Our Ref: A/88/17/L

Application for listed building consent for a single storey rear extension under pitched roof

The Old Cottage Station Road Angmering

PROPOSED ELEVATION 1:50

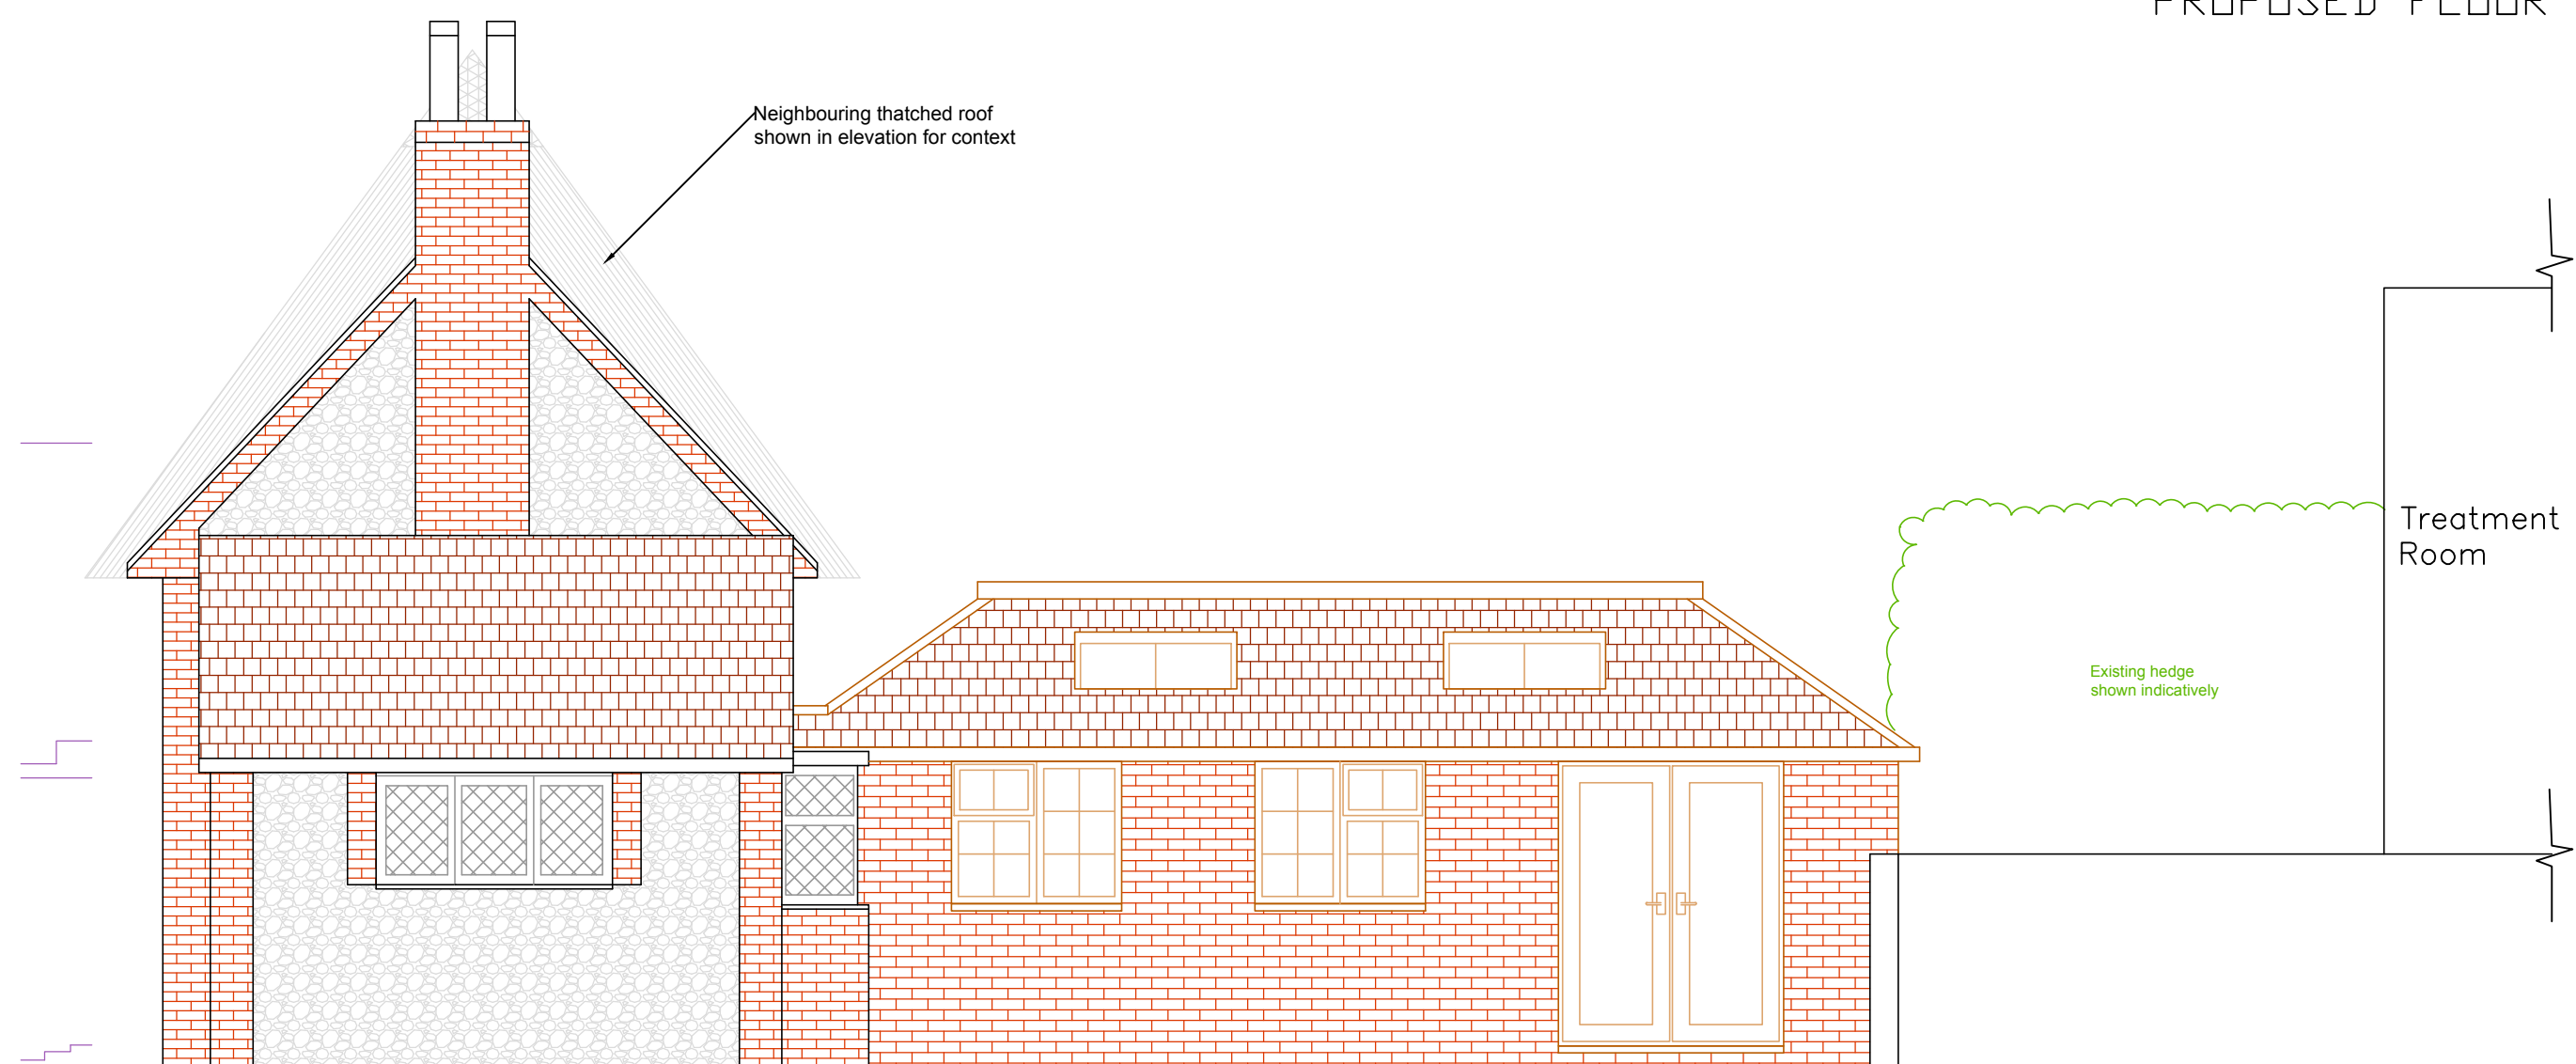
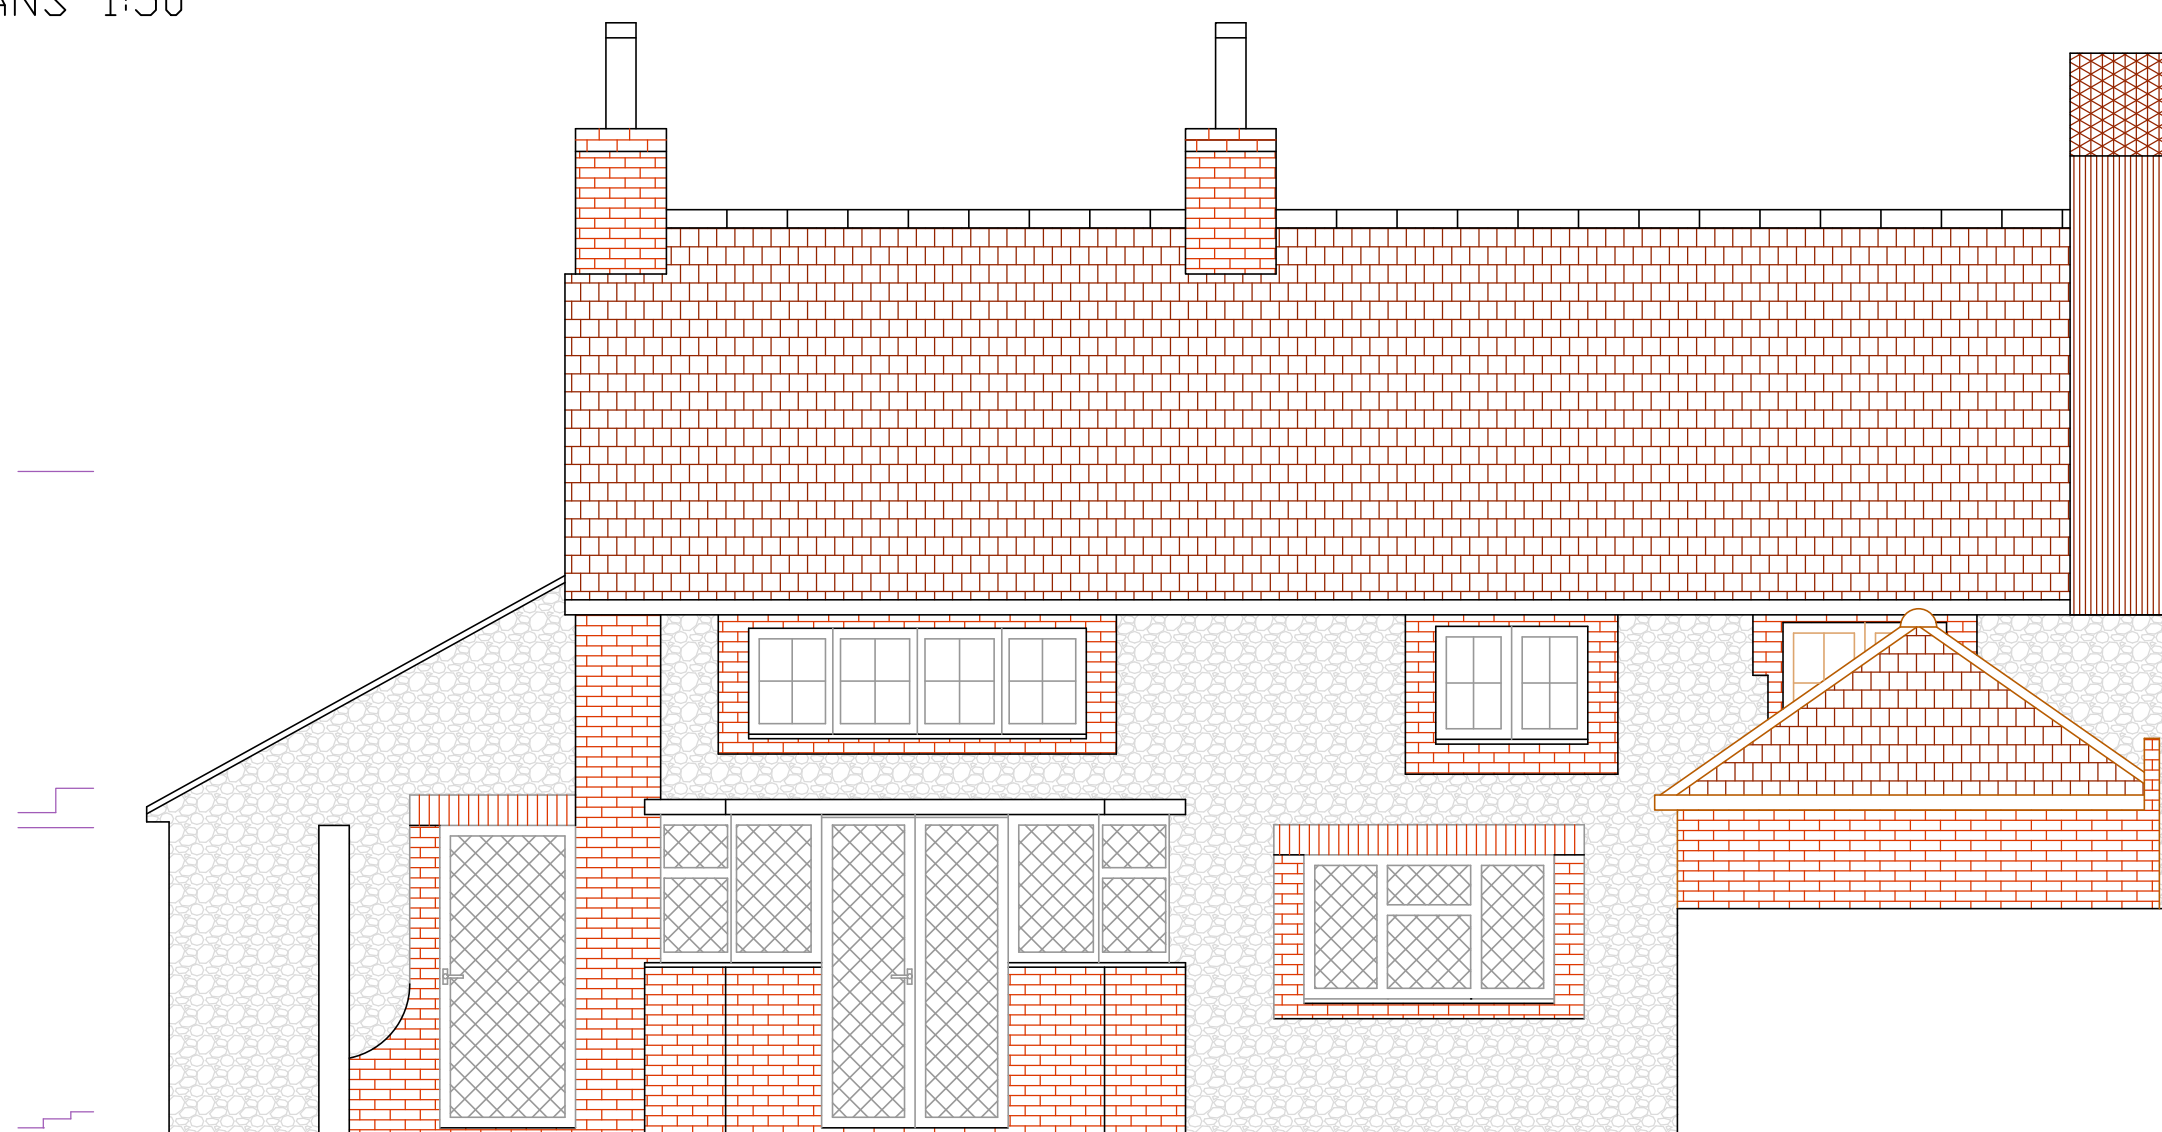
Design and appearance: The pitched roof is out of character with both the Old Cottage and the adjoining Old Mill House.

Visual Impact: It is intrusive and will completely change the appearance of the back of the cottage as well as impede on existing open views from the upstairs of the adjoining property.

Daylight/Sunlight: The height of the proposed roof will overshadow and significantly reduce light into the living room of adjoining property

Having lived in the Old Cottage for more than 20 years I can confirm that the height of the kitchen is comparable with new build housing and I do not believe that there is any benefit to increasing the height in this way. If additional light is needed in the kitchen then a lantern type roof light might be less obtrusive.
